**Consultation Response from Alan Smith,  
KC Waste Strategy (Refuse & Recycling)**

**2025/93355 Land off, Woodward Court, Mirfield, WF14 0PY**

**Erection of 75 residential dwellings with associated landscaping, open space, highways and drainage infrastructure**

**Responding Ref: WPN 25 048**

PROJECT	WOODWARD COURT, MIRFIELD
DRAWING TITLE	REFUSE VEHICLE SWEPT PATH ANALYSIS

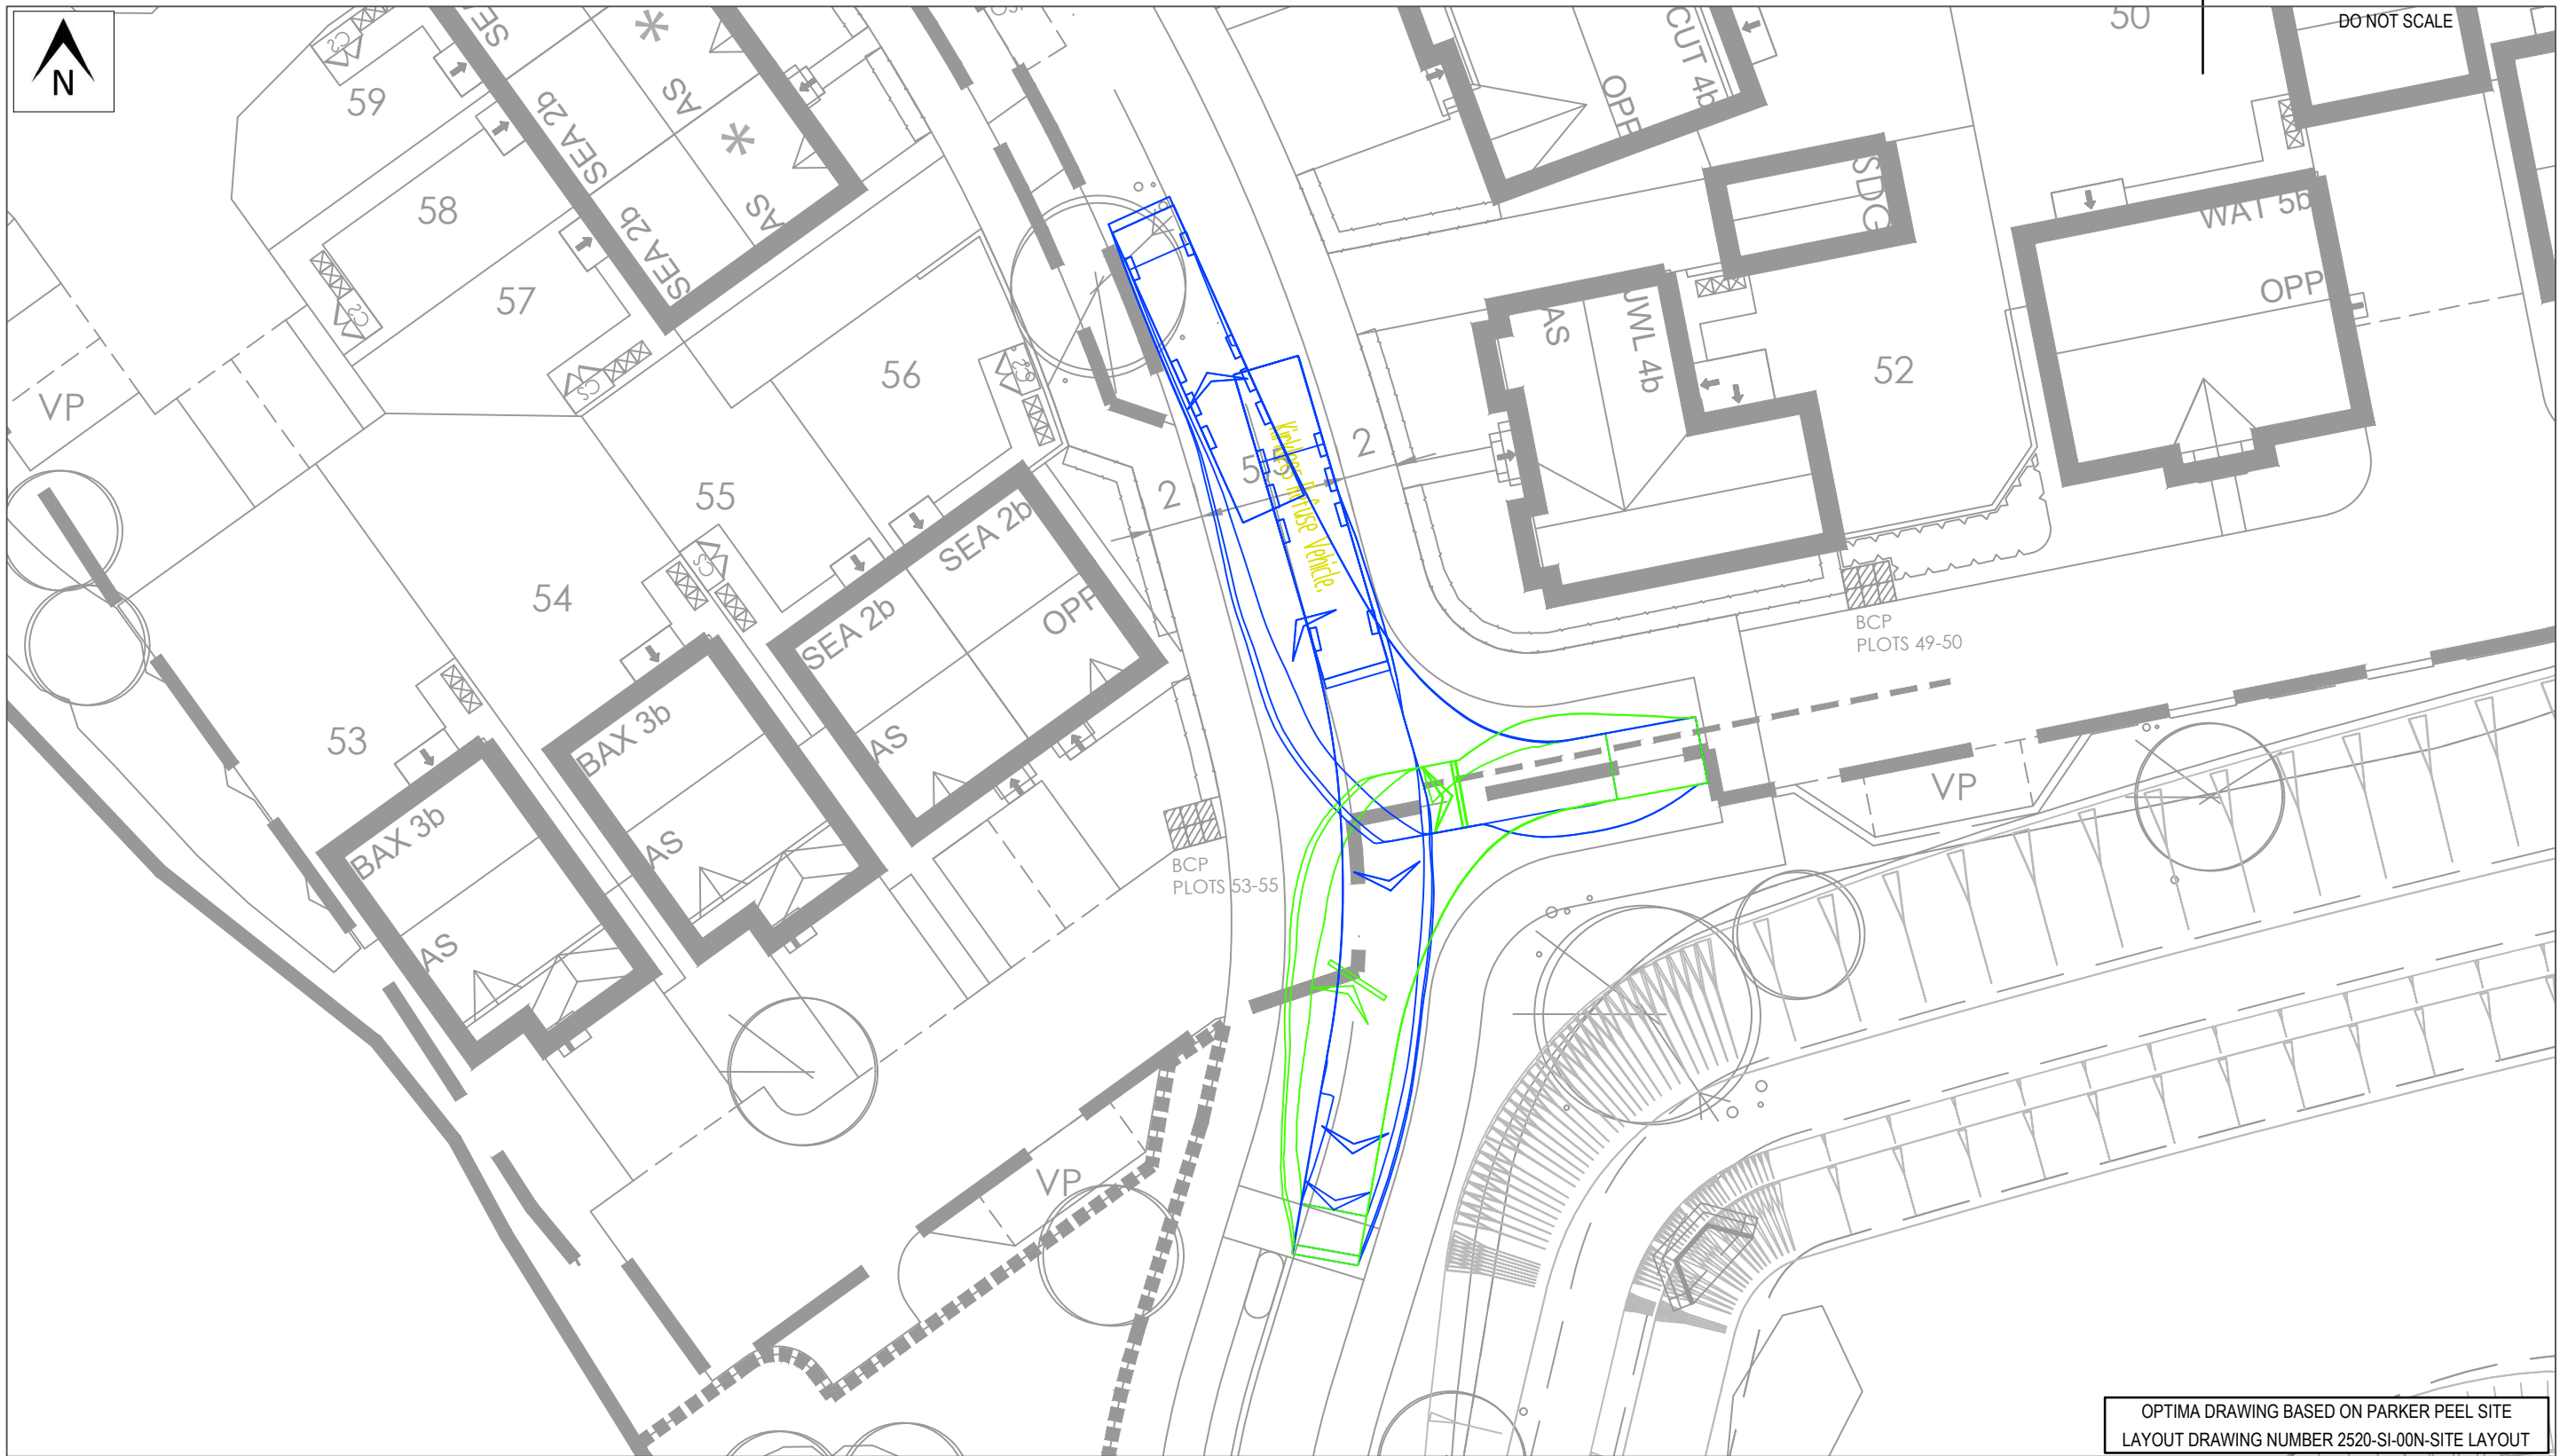
- The WCA will not enter:
  - Private drives
  - Roads not built to an adoptable standard
  - Active construction sites
- Road layout must:
  - Enable looped access (preferred over cul-de-sacs)
  - Where applicable, turning heads must be suitable for an 11.85m RCV
  - Turning areas must be made active to avoid them being used for additional parking
- Reversing distance for an RCV must not exceed 12m (WISH guidance)
